Subject: Application 3/2018/0220 & 0221 - Thornbers, Waddington
Attachments: THORNBERS RESPONSE.pdf; internal_wall_insulation_application_guide.pdf; site_mix_lime_screed_amp_wearing_surface_for_use_with_technopor.pdf; Ventrolla - Brochure - Bespoke New Timber Windows.pdf; Ventrolla - Brochure - Sash Window Renovation.pdf; PGB-2931_Proposed_20.07.18.pdf

Application 3/2018/0220 & 0221

Thornbers, Waddington – listed Grade II

Proposed Floor Plans
 DATE 13.07.18

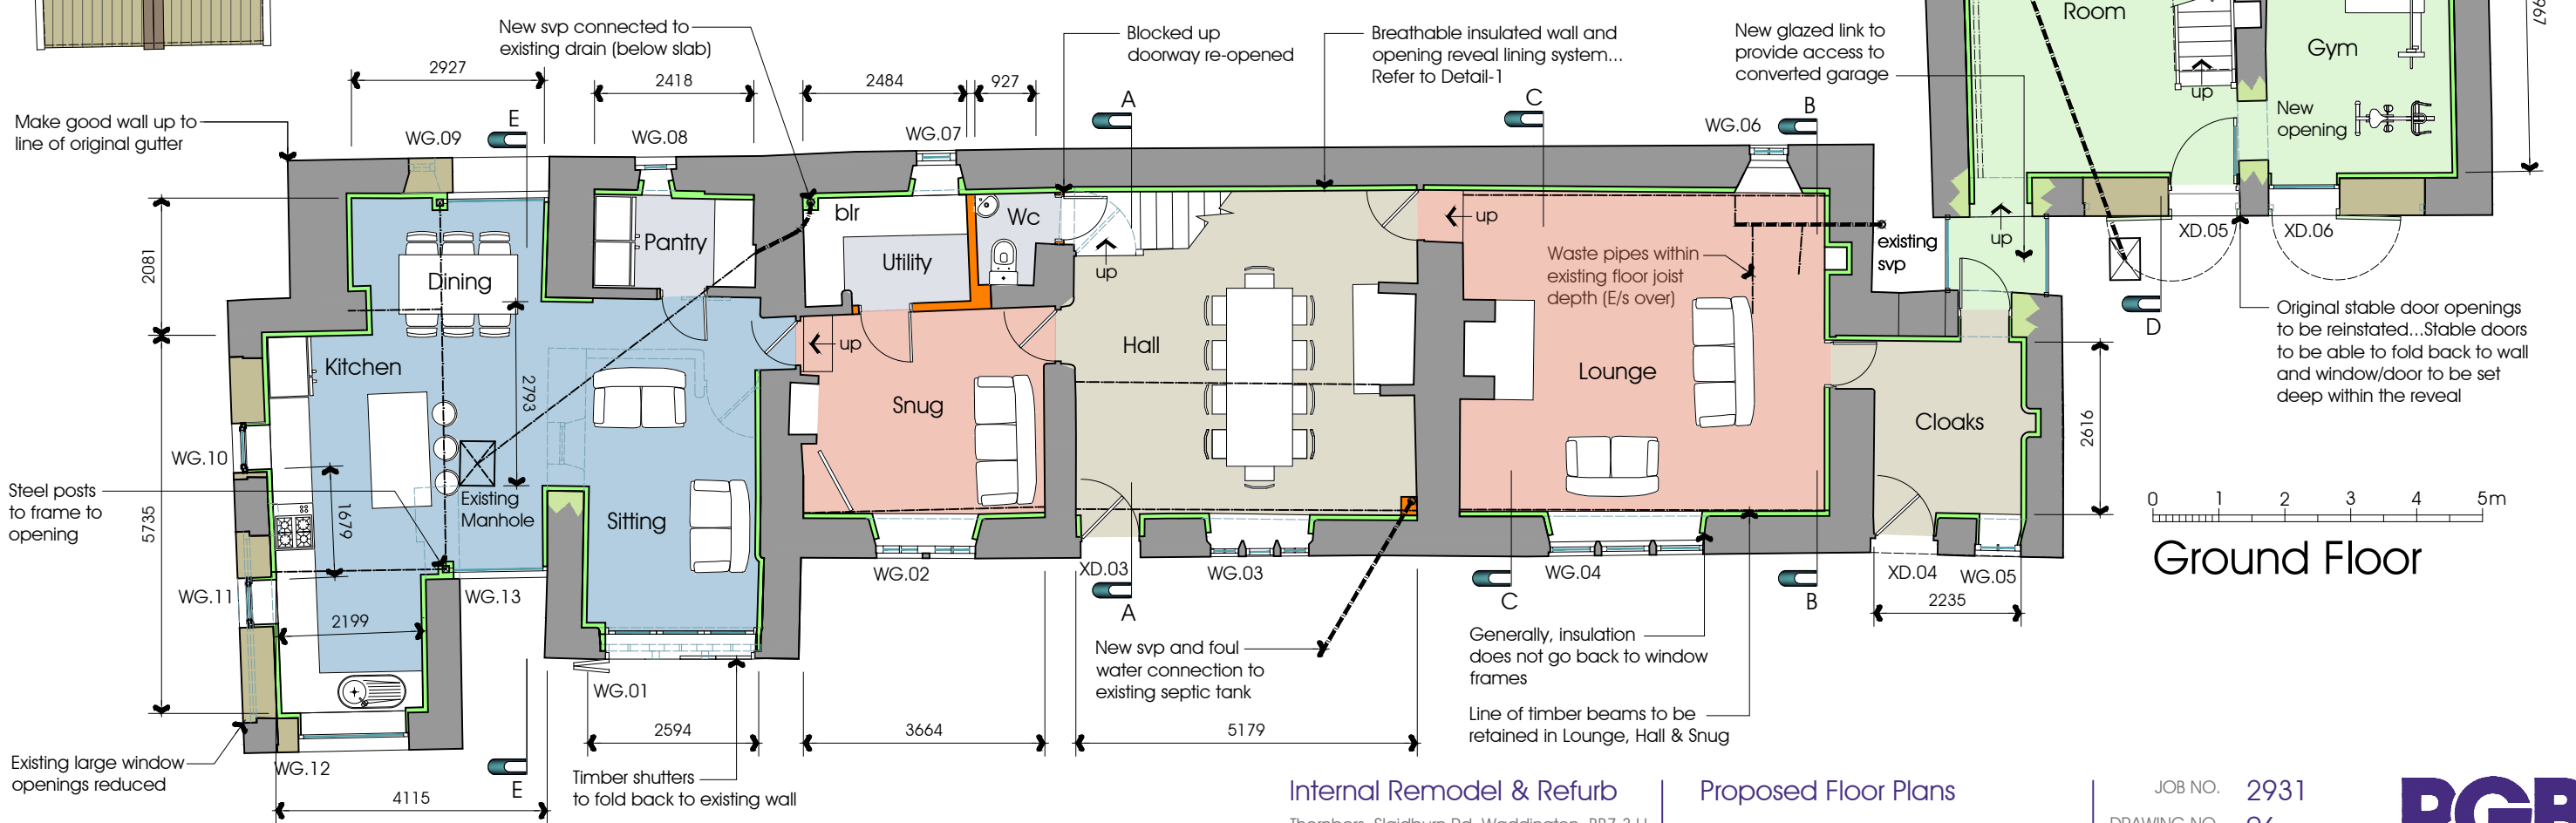
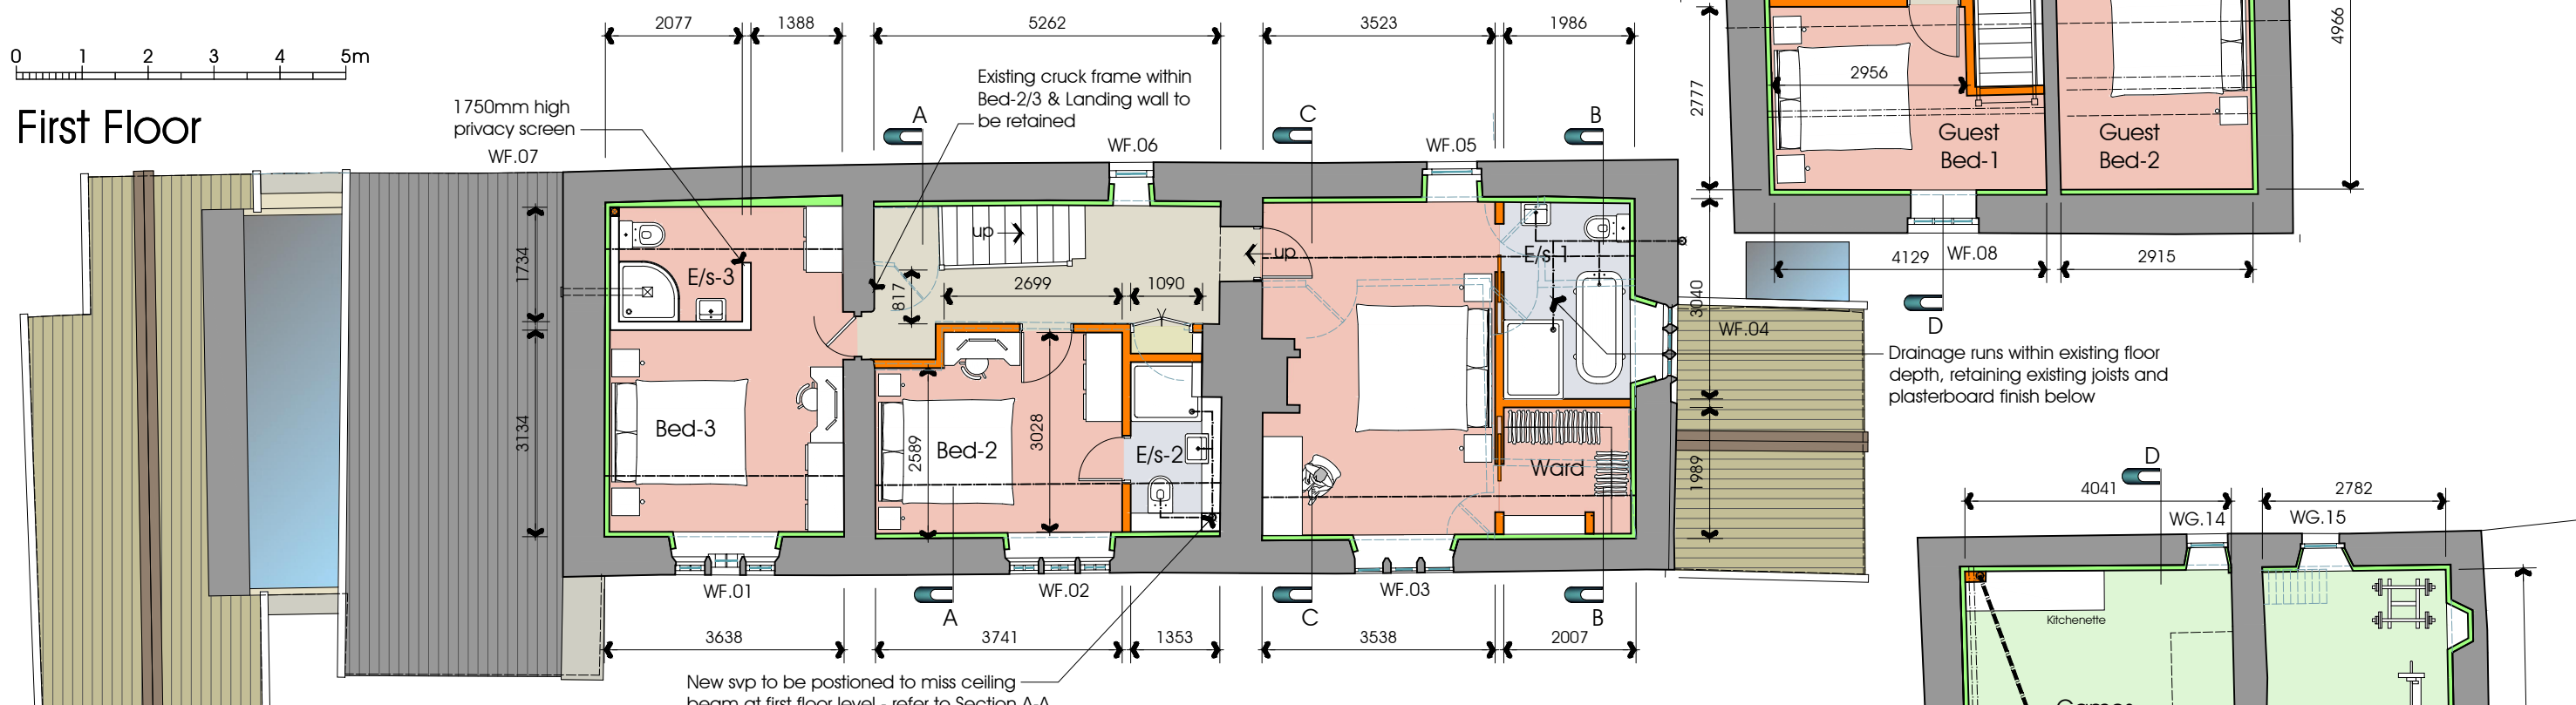
proposed in C17 fabric (close to the east gable and its window). Can a link be created which avoids loss to fabric of High Significance?

Proposed Bed 3 would appear to be the only First Floor room which has retained its original proportions (C17 or earlier). As discussed on site, I would therefore welcome further consideration to retaining this important element of planform in the proposed works.

We note your appeal decision attachments and have not been certain of the implication of this, however in response; we have now adjusted the location of the frame-less glass link to reduce its surface area significantly and; so we do not affect the fabric of the older parts of the property. The glass link being very short does not need to be artificially lit and will also use none reflective glass as will the glass to the kitchen link. Please be more specific if the appeal documents implied something else.

We acknowledge your concern with regard to the subdivision of bedroom 3 and propose a 1750 high privacy screen so that the original shape of the room is retained

South (front) elevation 0 1 2 3 4 5m

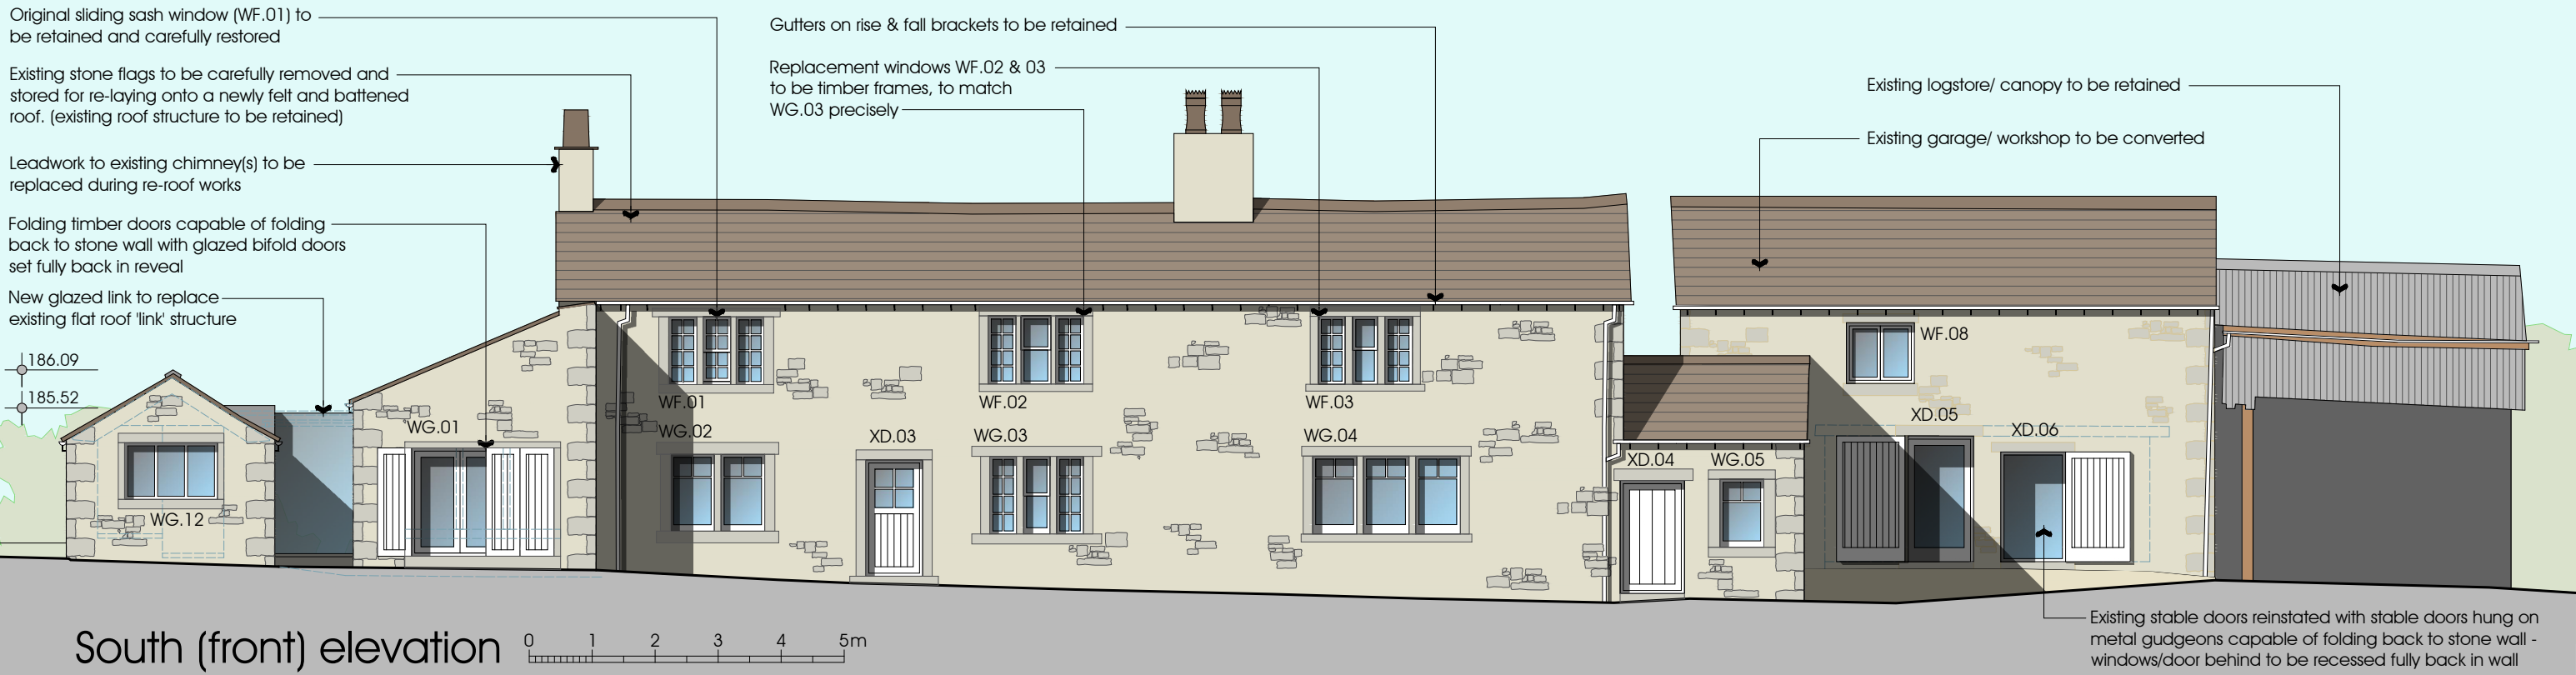
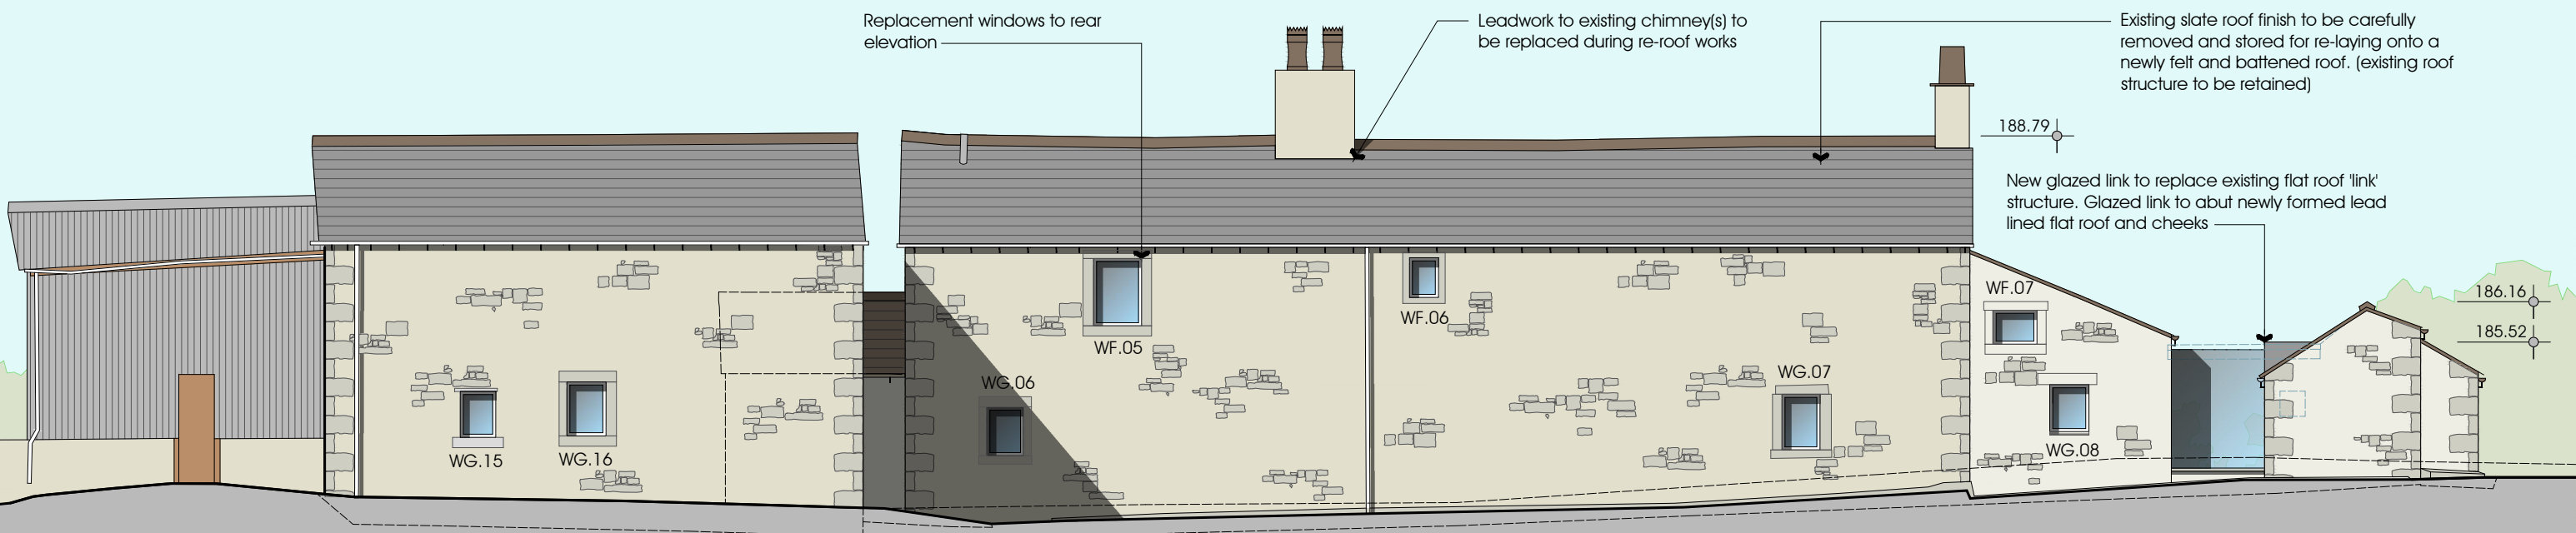
I welcome proposals discussed on site to minimise the impact of new fenestration in the former stables, cartshed/garage and garden room (extent of glazing and number of lights to the former ancillary building windows which competes with the higher status main range). For information, I attach a link to Historic England advice and recent appeals.

Mindful of the loss of character to the front elevation of the former stables resulting from 3/1993/0641, has consideration been made to possible enhancement from restoration of the tall and narrow doorways? (stables are discussed at page 66 of <https://historicengland.org.uk/images-books/publications/historic-farmsteads-preliminary-character-statement-north-west/>).

I would be grateful for the submission of further information concerning the significance of existing windows and how this has informed proposed replacements. I recall from pre-application discussions that there was speculation as to whether window WF.01 was original to this house? Why does proposed window WG.03 not conform to that shown in Figure 6 of the Heritage Statement? Are windows WG.02 and WG.04 based upon historic windows or is there enough evidence to suggest replacements follow the style of WF.01? The 8-pane side windows to WG.03 (Figure 6) appear in proportion and in line with the central light – is there enough evidence to suggest the 6-pane 1970s side windows throughout the elevation could be replaced with 8-pane?

I am concerned that the proposed window beads referred to at page 4 of the Planning Statement will not safeguard the character of prominent front elevation windows (see Historic England advice in respect to the replacement of windows <https://www.historicengland.org.uk/images-books/publications/traditional-windows-care-repair-upgrading/>).

We have adapted the windows in line with our telephone discussion to use sliding sashes without glazing bars and 8 panel fixed lights either side. We have however kept and propose to refurbish the existing sliding sash within WF01 because of its age and; whilst this appears to be a window from another building just fitted into this gap without too much care, we still feel it is an important story to this listed building - if you disagree and would prefer to match the proposed sliding sashes then please let us know.

We have reintroduced the original stable doors into the garage which helps strengthen the dividing wall and therefore allows us to provide a door between the two spaces in a more sensible location. If the fold back timber doors should look more like original stable doors then please advise. We have also tried to create a more agricultural feel with similar bi-folding screen to the original cart shed opening.
